**From:** Gregg, Robert <Robert.Gregg@lancashire.gov.uk>  
**Sent:** 19 February 2019 11:32  
**To:** Harriet McCartney  
**Cc:** planning; LHS Customer Service  
**Subject:** APP. 3/2019/0128 - 60 MAYFIELD AVENUE, CLITHEROE

### **Application to demolish existing garage on side of house and then build a two storey side extension.**

Proposed Ground Floor Plan

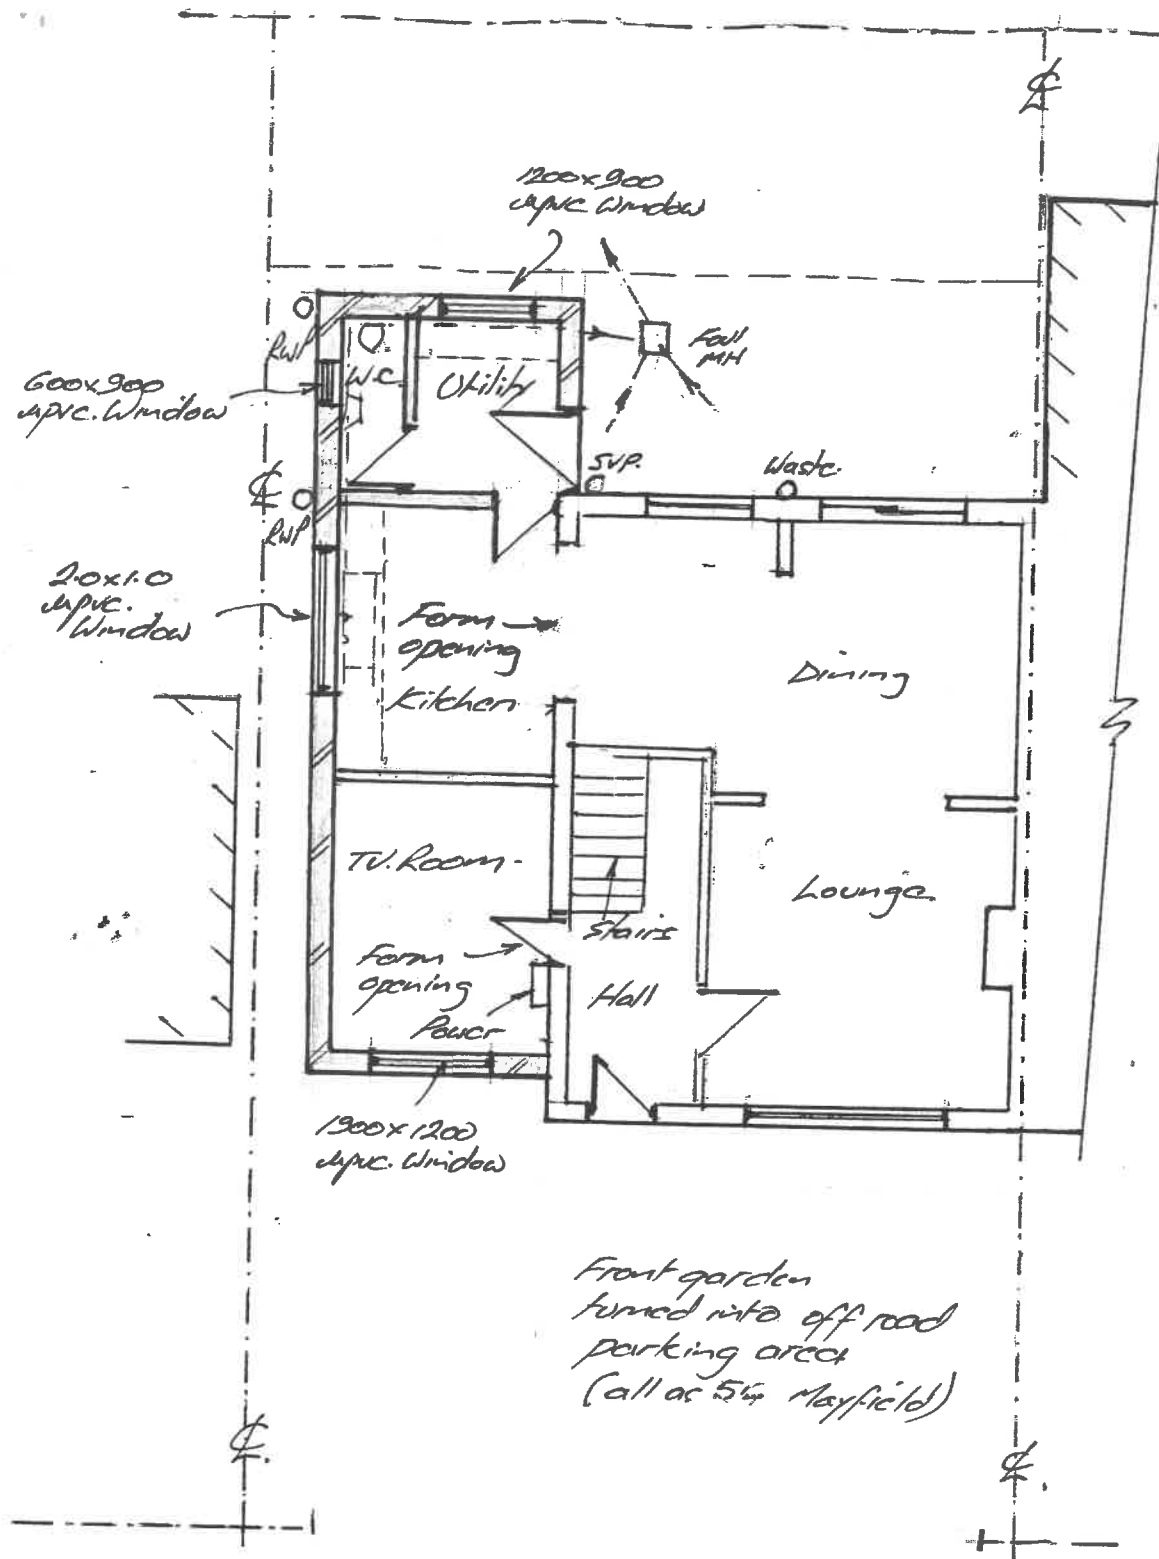
With respect to the application, the proposal will result in an increase in the number of bedrooms from 3-4 and as such 3 parking spaces will be sufficient for the proposal.

The loss of a parking space to the existing garage will be accommodated by an extension to the existing driveway to the frontage of the dwelling. The proposed driveway extension will suffice that of the required parking provision, however the proposed parking formation will need to be bound using an approved surfacing material as well as an extension of the existing drop kerb that will need to be installed prior to the commencement of any external works in accordance with the full approval of this application whereas these works shall be carried out under section 184 of the Highways Act 1980.

1. Before the area fronting the dwelling is used for vehicular purposes, the whole area shall be appropriately paved in tarmacadam, concrete, block paviours, or other approved materials. **Reason:** To prevent loose surface material from being carried on to the public highway thus causing a potential source of danger to other road users.
